Department of Primary Industries

**Kings Park Waste Metal Recovery, Processing and Recycling Facility
(SSD_5041) - Response to exhibition of Environmental Impact Statement**

Comment by NSW Office of Water

LEGEND

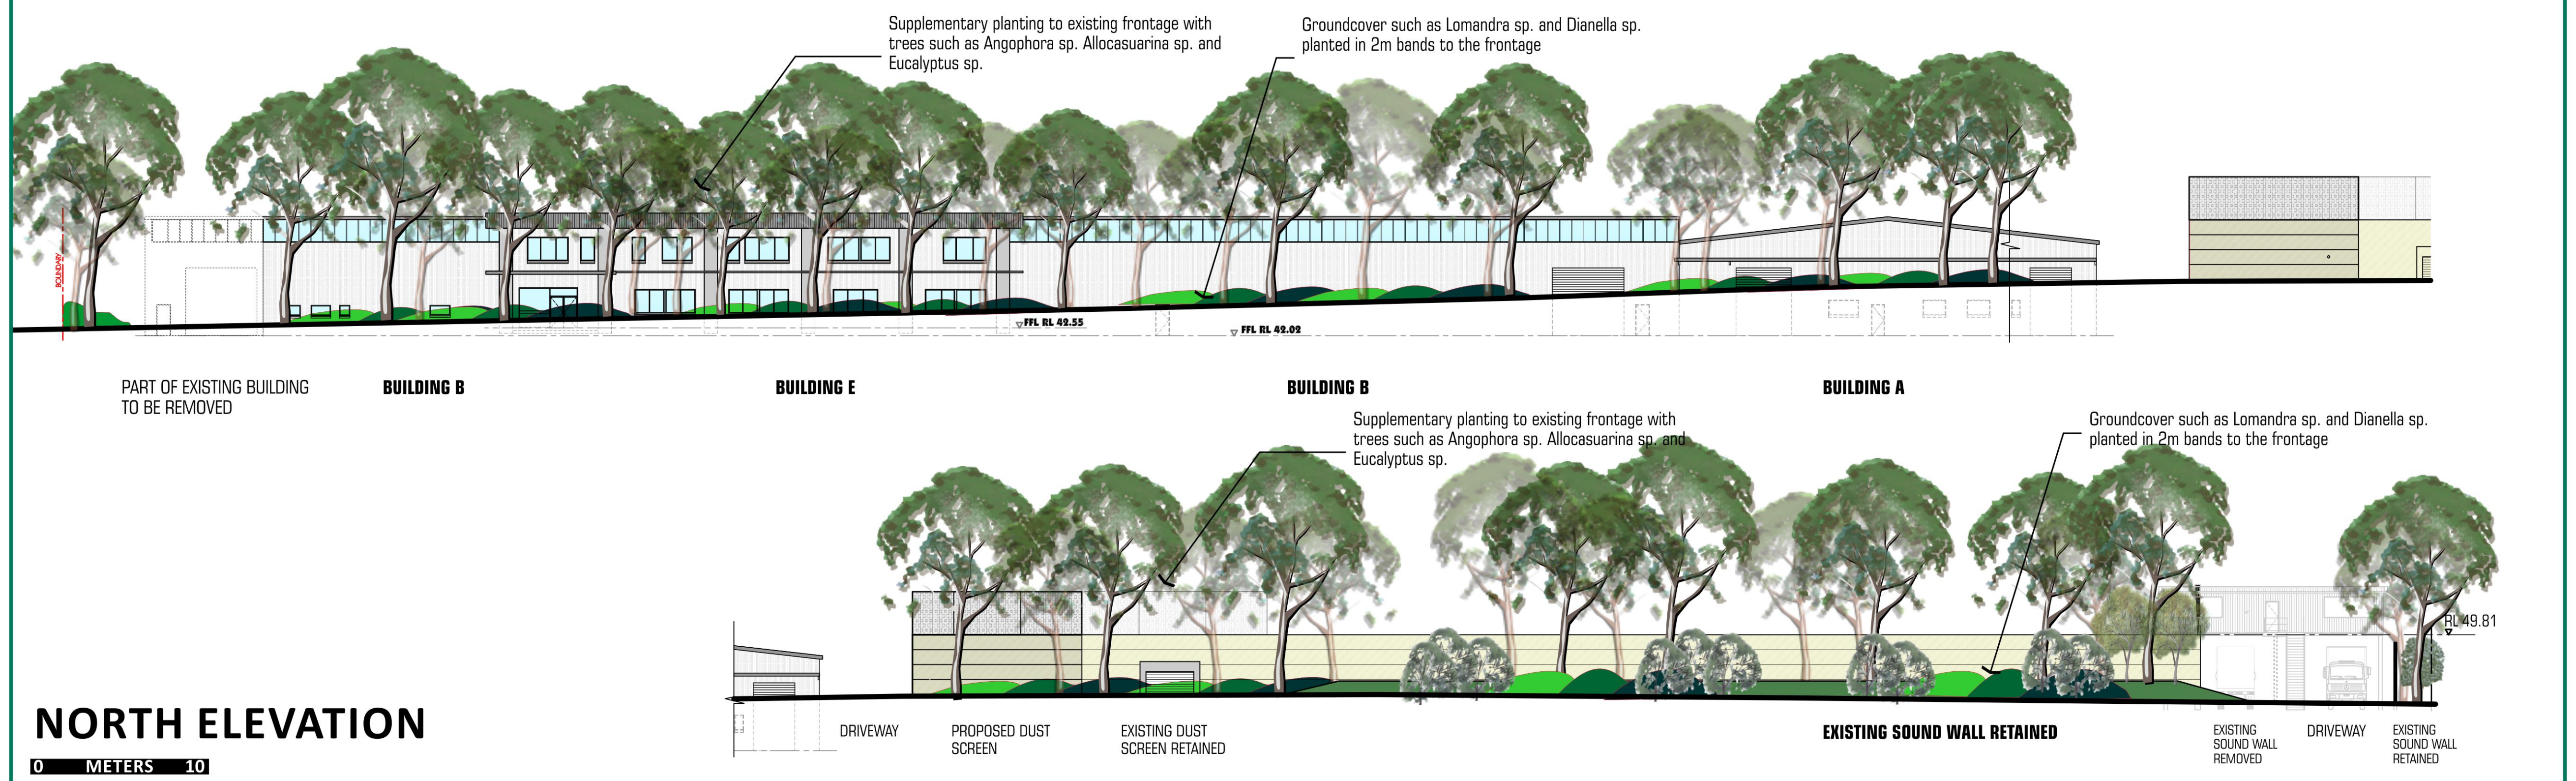
The Landscape Plan (Annex N) does not locate the riparian corridor footprint within the site boundary. The plan appears to show that a combination of seeded lawn, native trees and shrubs are proposed to be established within the riparian corridor but it does not indicate local native groundcovers are to be established.

The riparian corridor should consist of fully structured native vegetation (including groundcover species, shrubs and trees) from the relevant local vegetation community to improve riparian habitat diversity.

It is suggested the Landscape Plan is amended to show:

- the location of Breakfast Creek;
- the location of the top of bank;
- the footprint of the riparian corridor (measured from the top of bank) within the site; and
- the riparian corridor to be planted with native plant species from relevant local vegetation community, including trees, shrubs and groundcover species.
